**From:** [REDACTED]  
**Sent:** 28 February 2018 14:12  
**To:** Planning.Responses  
**Subject:** RE: Planning Consultation on: AB/148/17/PL

**App No:** AB/148/17/PL

**Address:** Wooded Land South West of Dalloway Road Arundel

**Proposals:** To provide 4 No. detached houses on existing semi natural woodland site. This application is a Departure from the Development Plan.

1:500 Site Plan as proposed

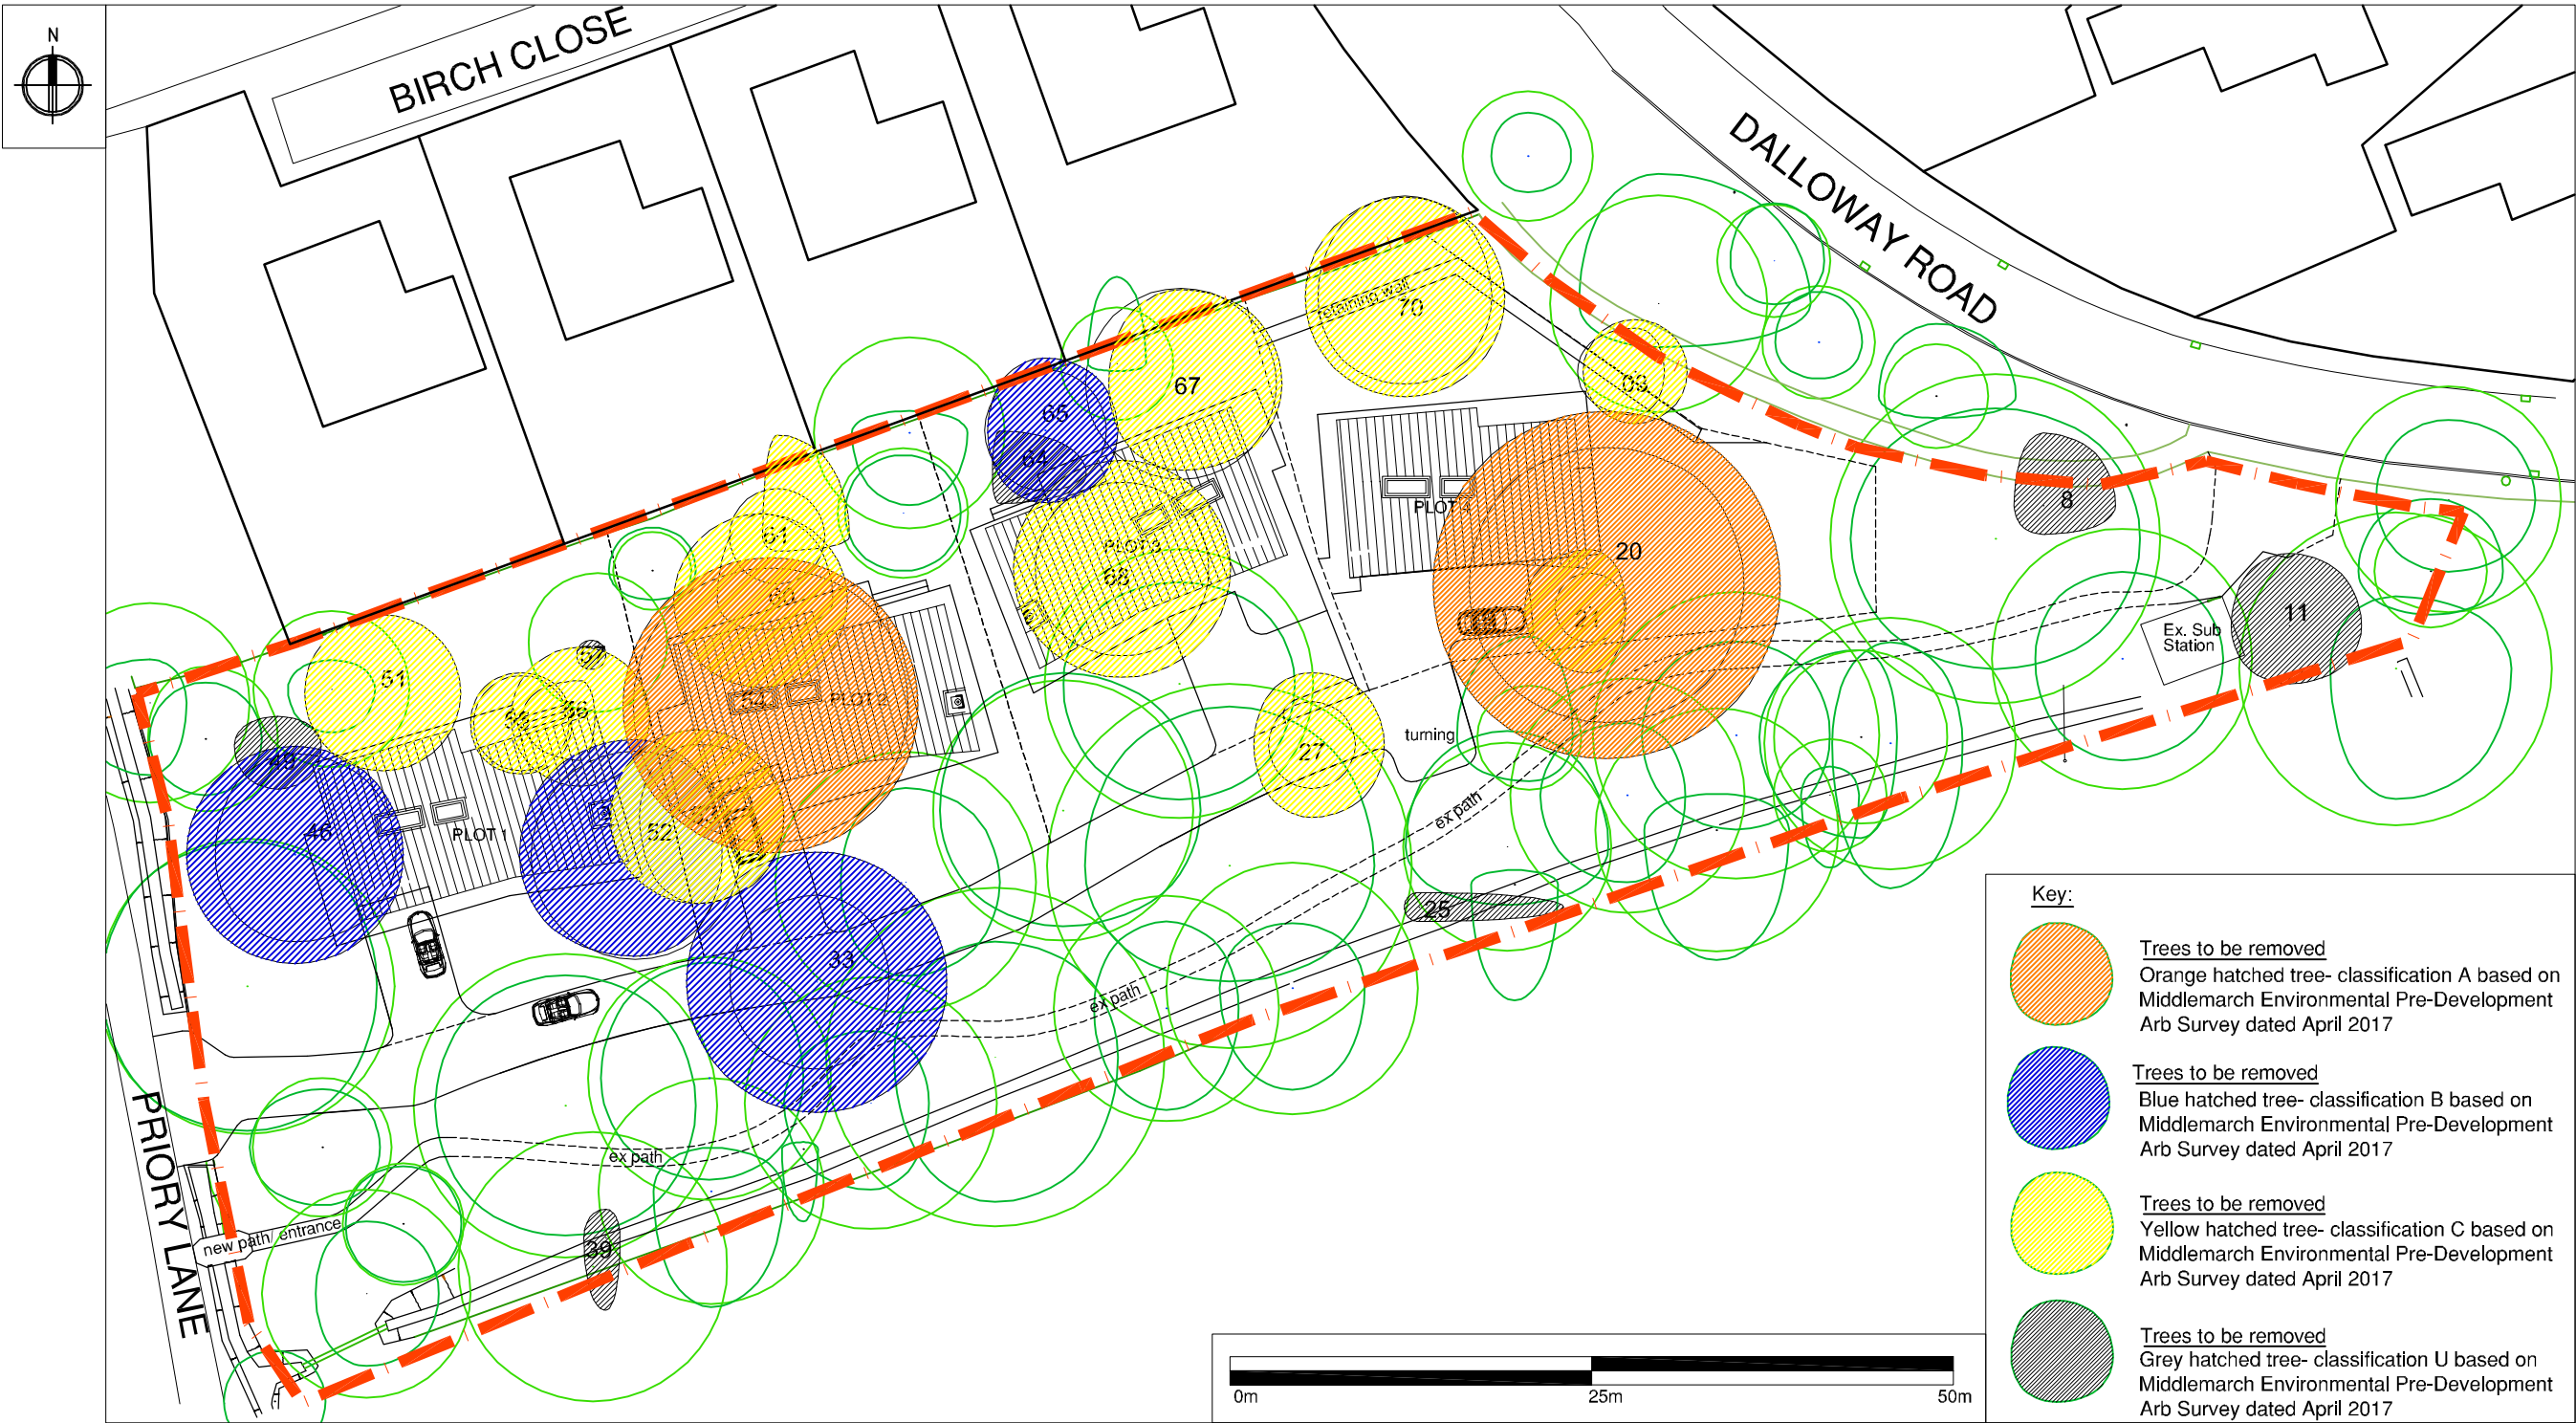
Due to the presence of ancient woodland to the site following Natural England's guidelines a 15m buffer must be put in place where no development or works can take place to ensure the ancient woodland is not negatively affected by the works. Fencing should be used to ensure this area remains undisturbed.
